# CITY OF ALBUQUERQUE

10-23-23

**Re: Roses Southwest Papers**  
**No address- UPC 101605227405540202**  
**Traffic Circulation Layout**  
Engineer's/Architect's Stamp 10-17-23 (Q16-DA5000C)

TRAFFIC CIRCULATION LAYOUT
- PHASE 1 ENLARGED

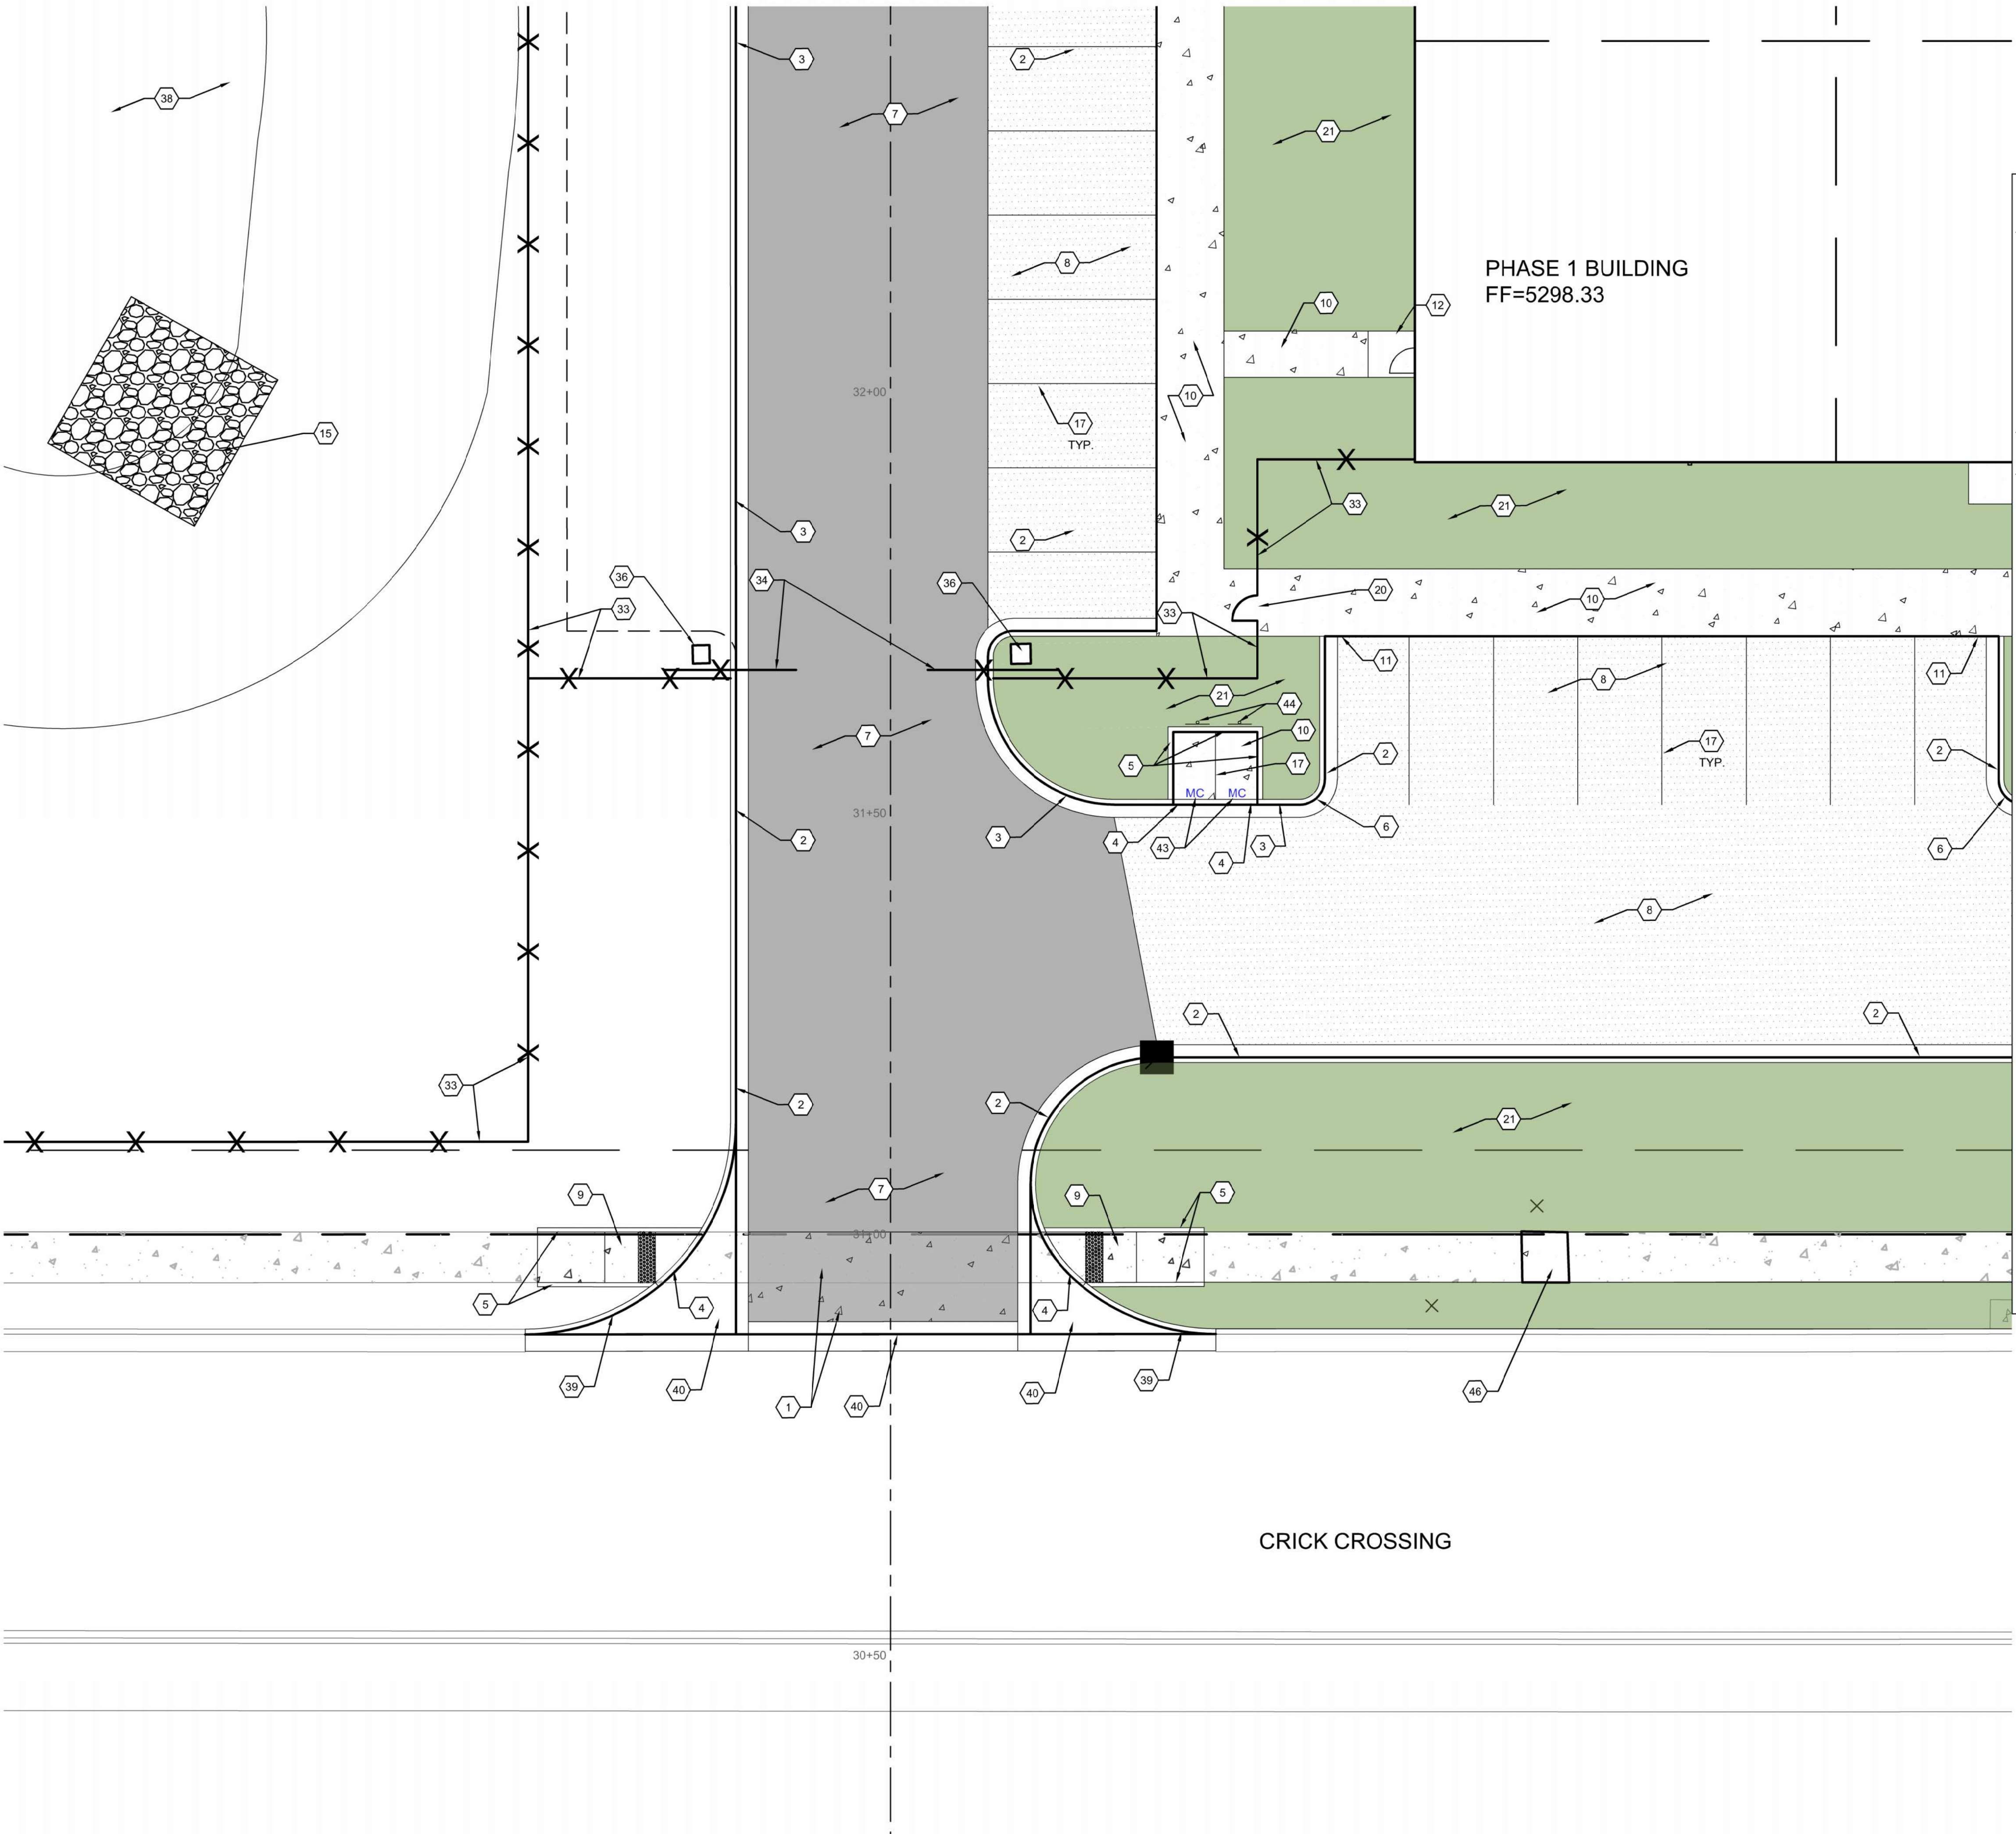
12. On Sheet TCL-1B you are showing a manhole in the center of the valley gutter. It can be difficult to construct the valley gutter invert with the manhole pad/cover (for info only).

13. The driving surface into the MC parking is to be flush with the parking lot. It appears there is a curb. See keyed Note 3.
14. Please show the ADA path across drive entrances Sheets TCI-1D and 1E.

22. Add a note stating "All broken or cracked sidewalk must be replaced with new sidewalk."
23. There are a couple small stumps in the sidewalk near Keyed Note 46 Sheet TCL-1E that should be removed.

HORIZONTAL CONTROL PLAN -
PHASE 1 ENLARGED

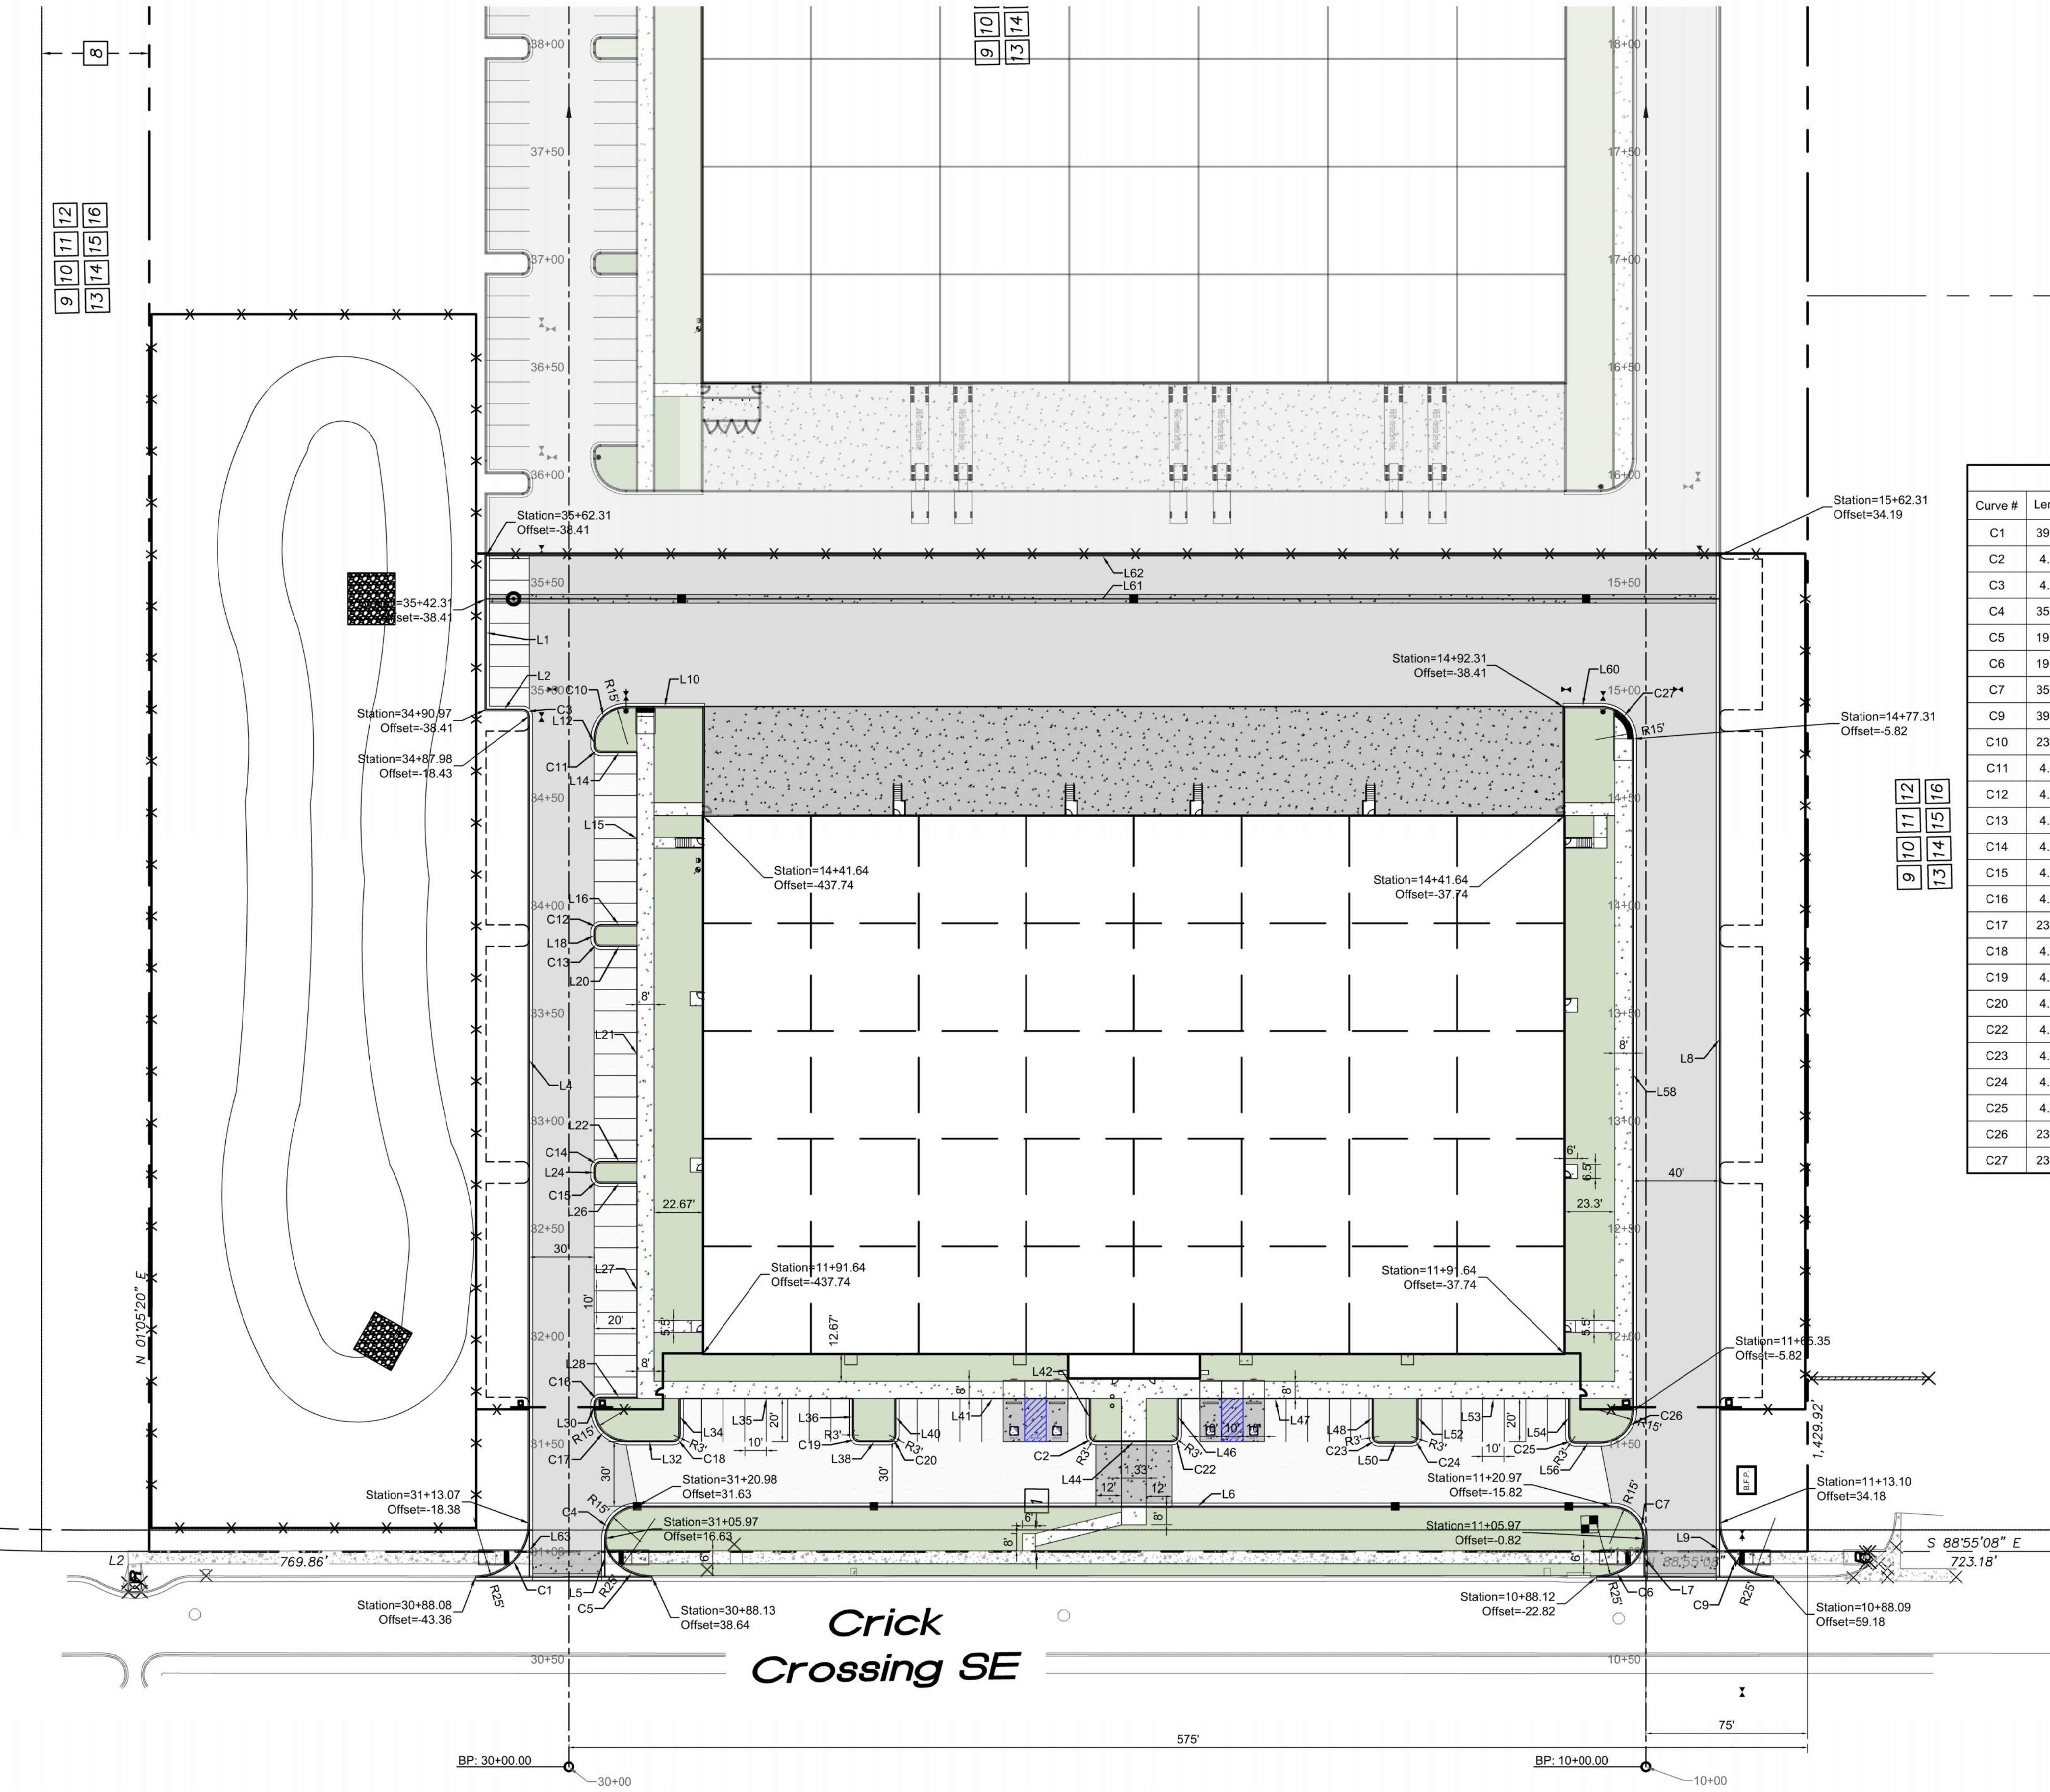
20. Please change "Crick Crossing SE" to "Crick Ave SE" . It is shown on the street.
21. Please show the concrete infill at the ramps per CLA STD DWG 2443.
